From: Jean Fraser
To:
Subject: Fwd: RE: RE: Urgent re Jewish Community Center - 1342 Congress St
Attachments: J0094-OFFSITE GRADING PLAN.PDF; PortlandJCAEventParkingMemo.pdf; J0094-SITE PLAN-6-9-15.pdf

Per your request I have attached a revised Site Plan for discussion with Planning Board today that has some of the revisions based on last week's meeting. I have also provided a response to the 'Next Steps' included in your Memo to the Planning Board, so the Board understands our progress toward addressing the following:

SITE PLAN LIGHTING

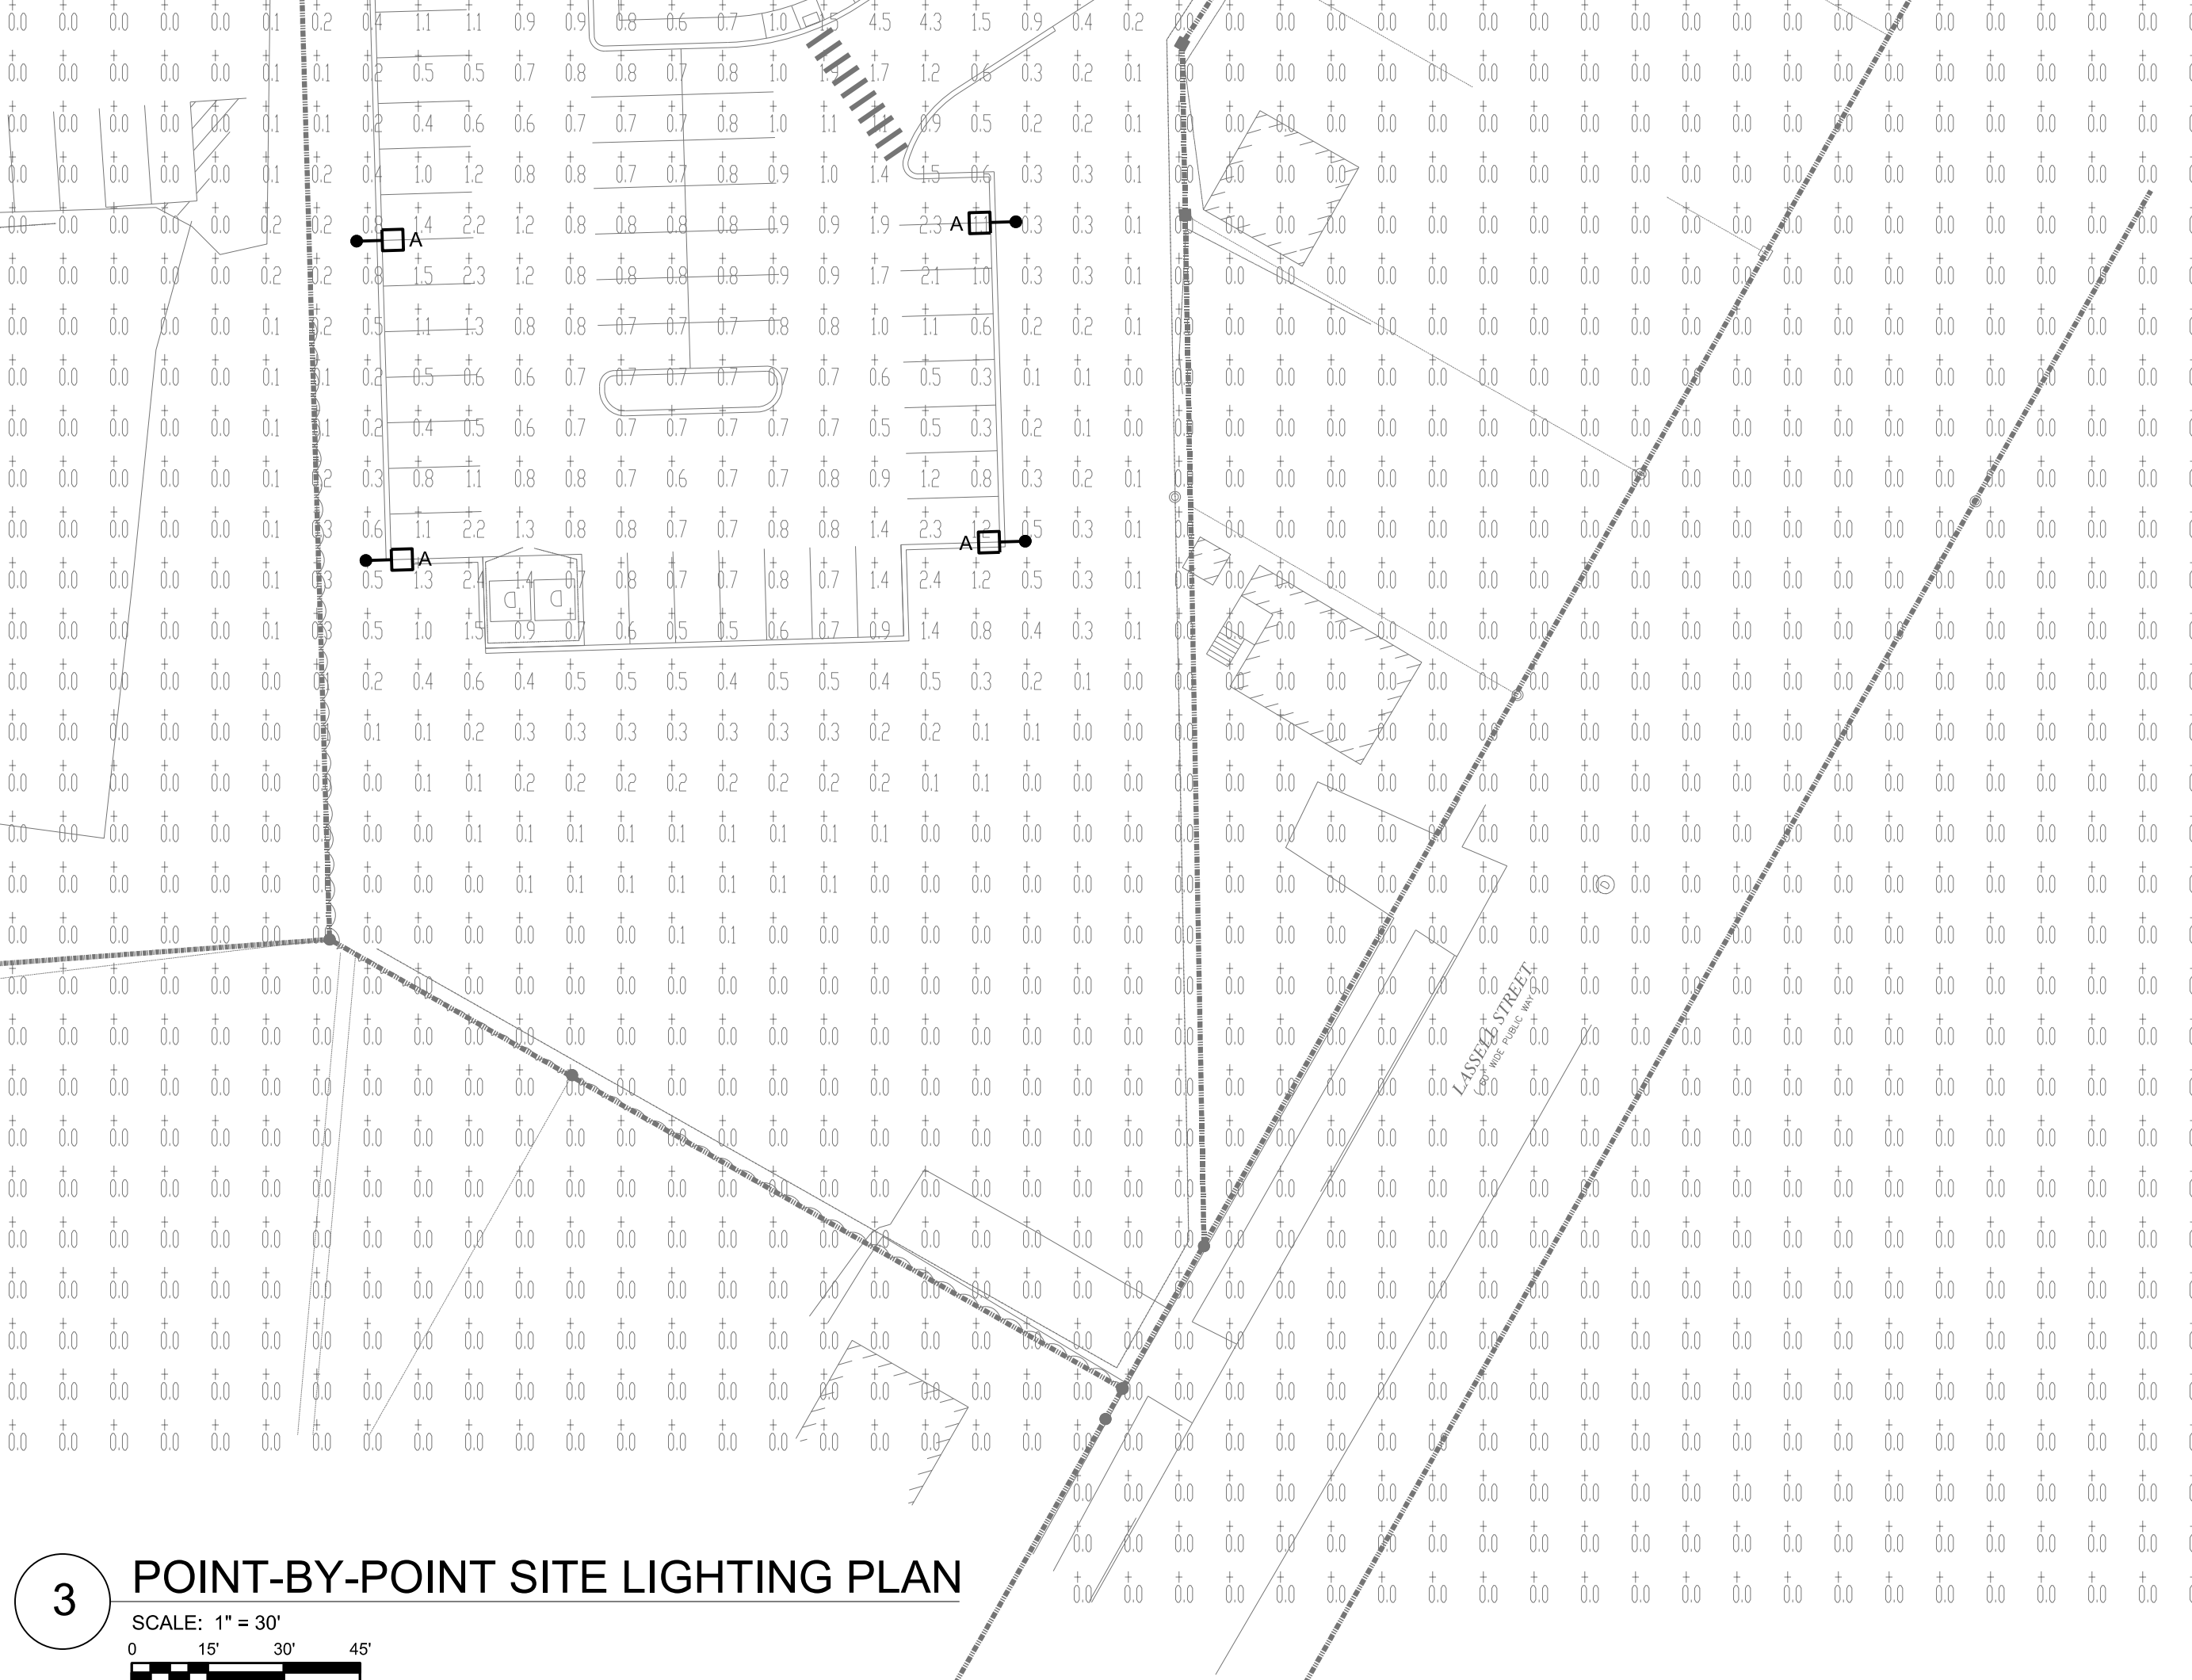
7. Revise lighting to avoid light trespass and clarify whether existing lighting is adequate along the Congress Street drive and building entrance.

· *The Photometric Plan will be revised to limit light trespass onto abutting properties and to include building lighting to determine if lighting on Congress Street driveway is sufficient.*

OFF-SITE
 GRADING AND DRAINAGE PLAN
 SCALE: AS SHOWN
 C-10

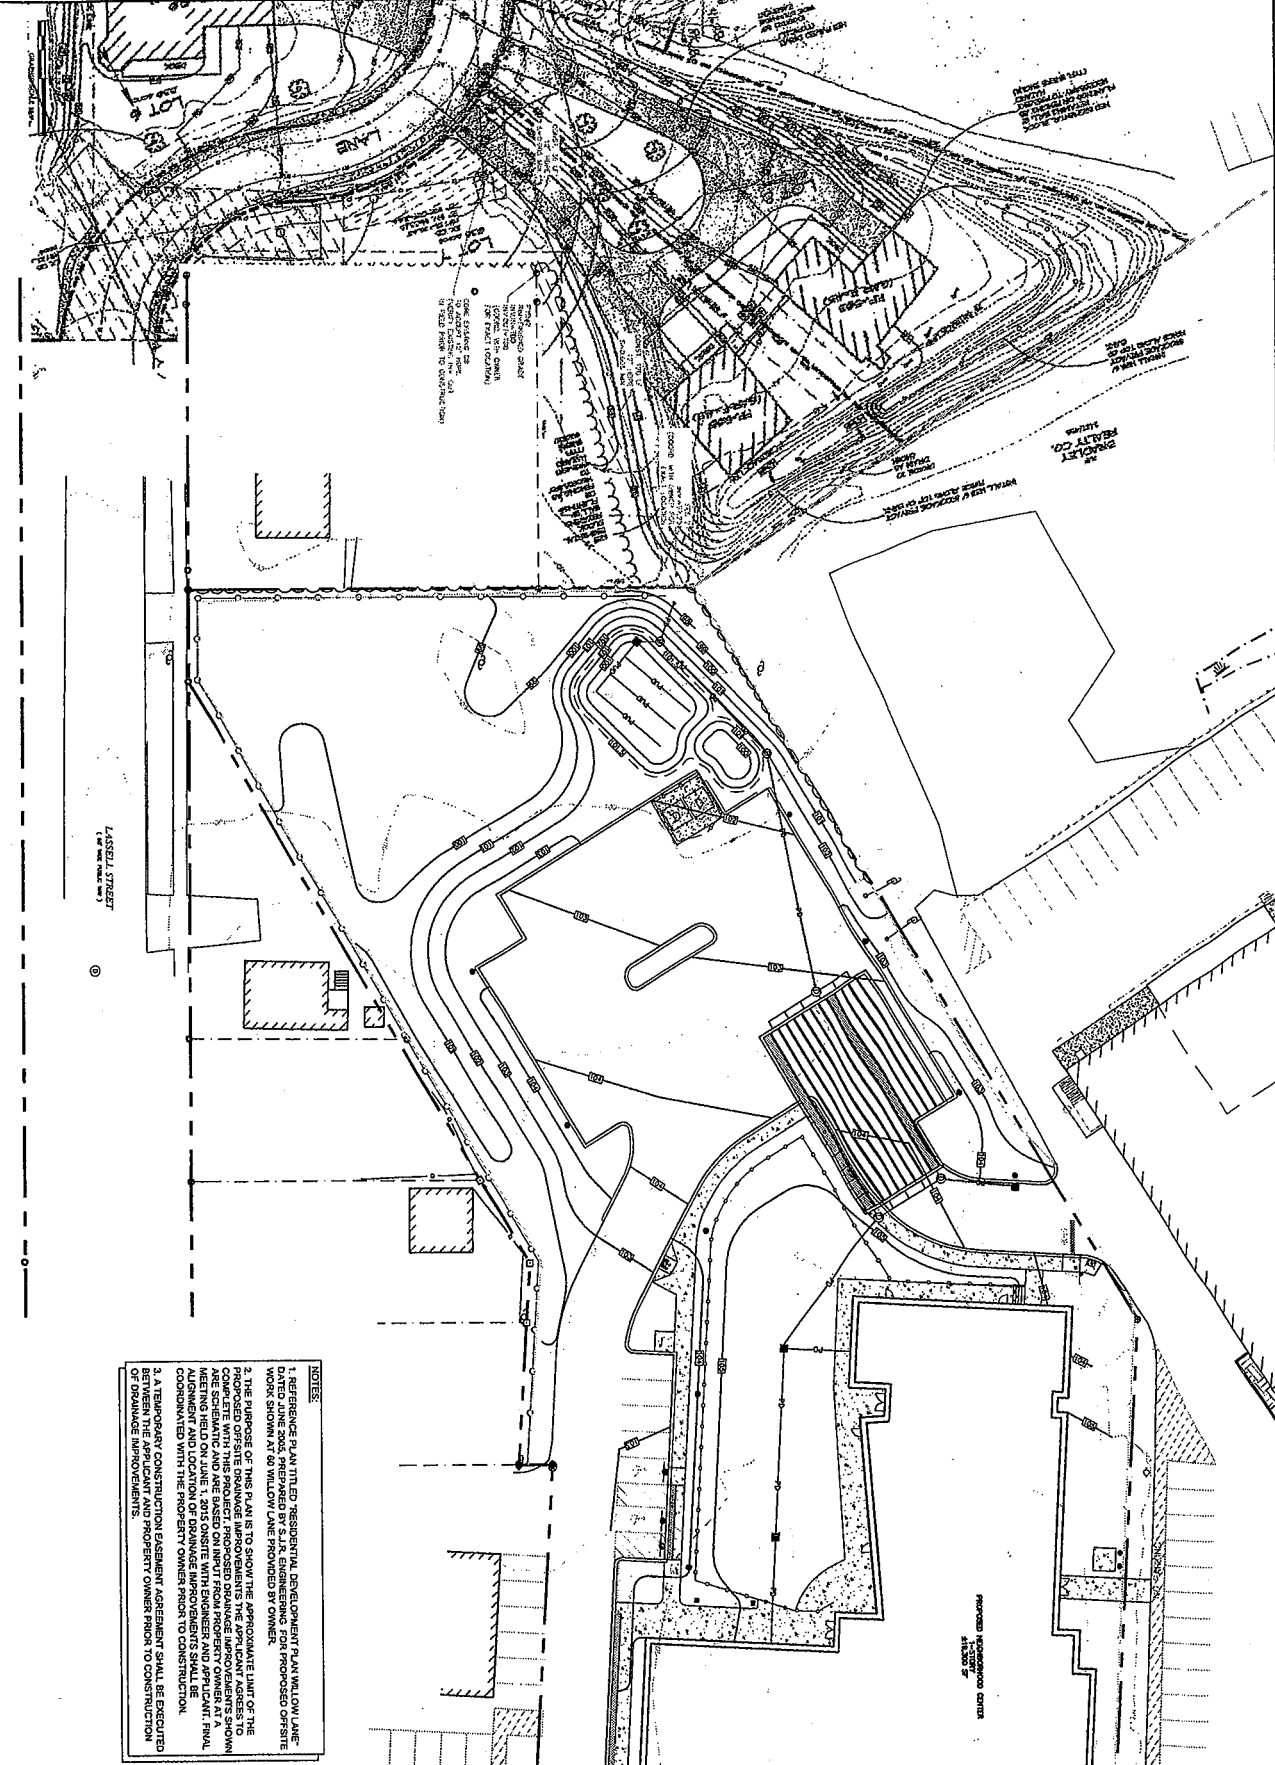
6. Undertake further research and discussions with neighbors to address the two substantial concerns outlined by the Peer Engineer regarding the stormwater flow impacts.

· *We met with the abutter at 60 Willow Lane on June 1st, whose property receives the runoff generated from the existing site. Based on our discussions and his concerns the Applicant has agreed to complete drainage improvements completely on his property, so an easement would not be necessary. I have attached a rough preliminary sketch of the proposed work. The Applicant and Abutter are in agreement on the scope of the work and details will need to be worked out along with a temporary construction easement. Dave Senus approved of this approach.*

SITE PLAN

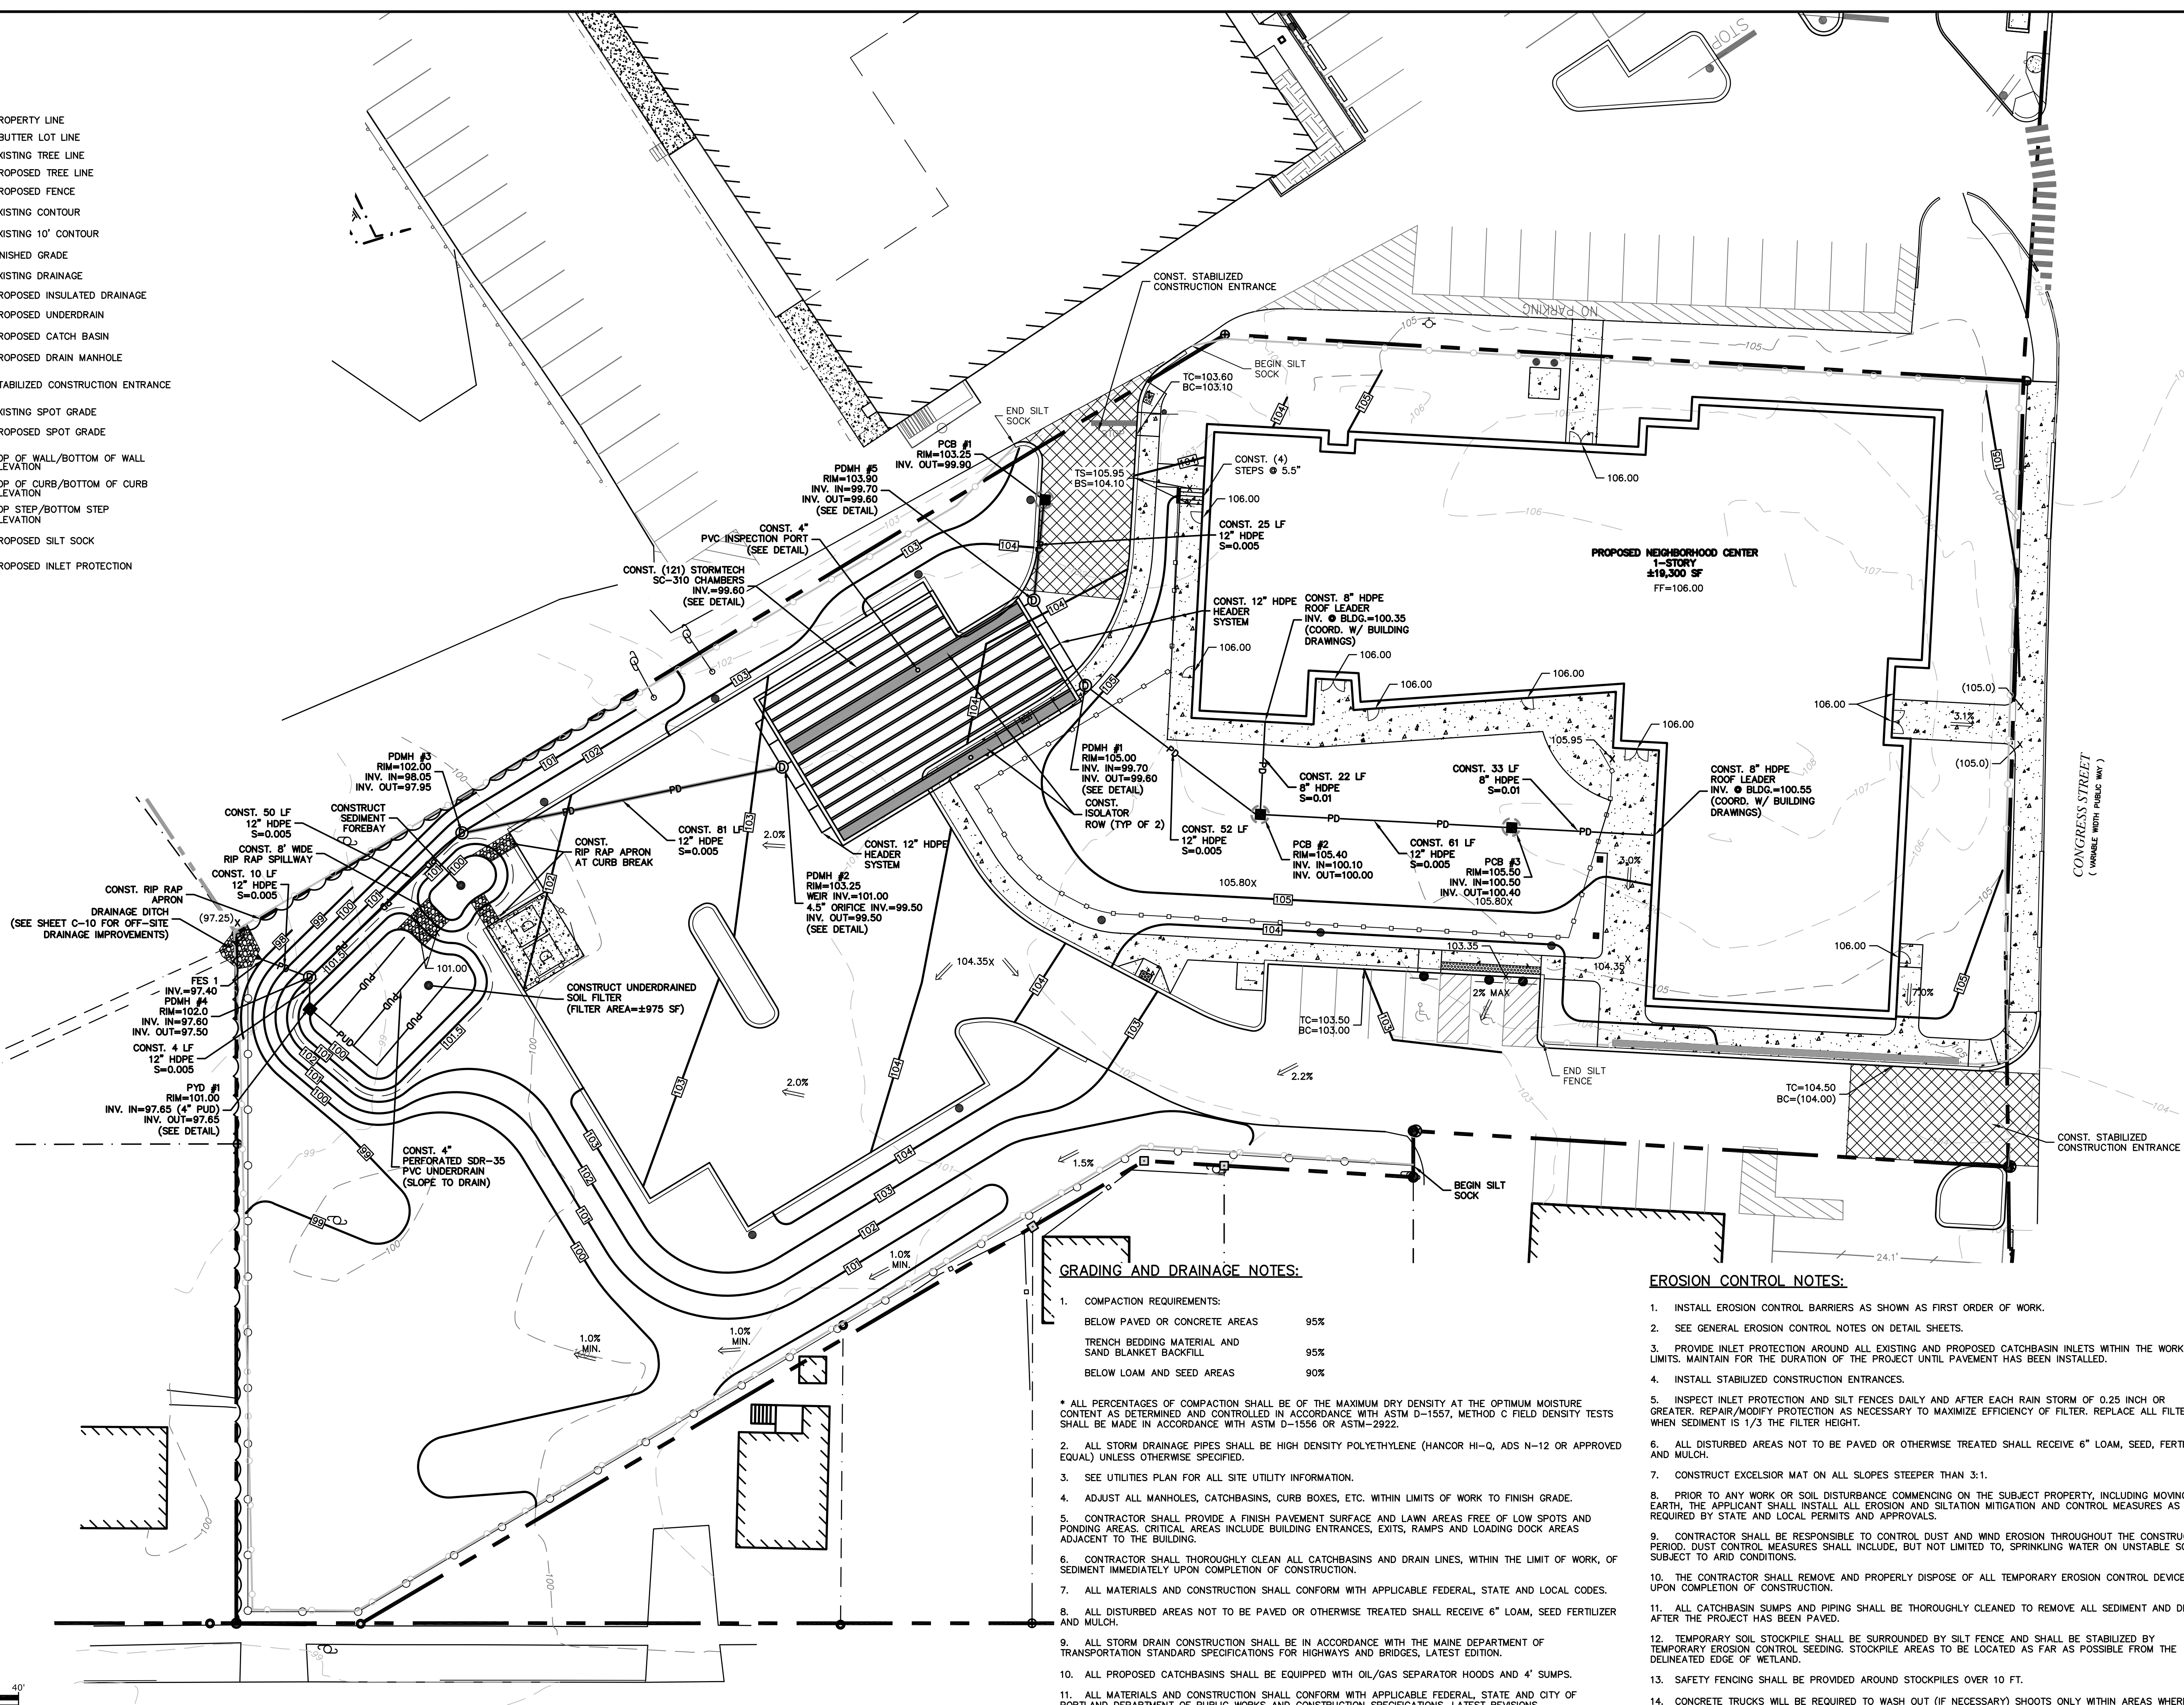
4. Develop designs to delineate the Congress Street drive where it abuts the dental offices, to incorporate street trees/landscape and possibly lighting (and clarify re a waiver for the width of the drive).

· *The enclosed revised Site Plan includes a landscape island to help delineate the driveway off Congress Street. The Applicant is working with the adjacent property Owner (Merlin Management Company) for permission to construct the island, which is also included in the above referenced Parking License Agreement. The proposed landscape island does not impact existing parking on Merlin Parcel. Landscaping will be provided and the project Landscape Architect is working directly with the City Arborist to address his comments.*
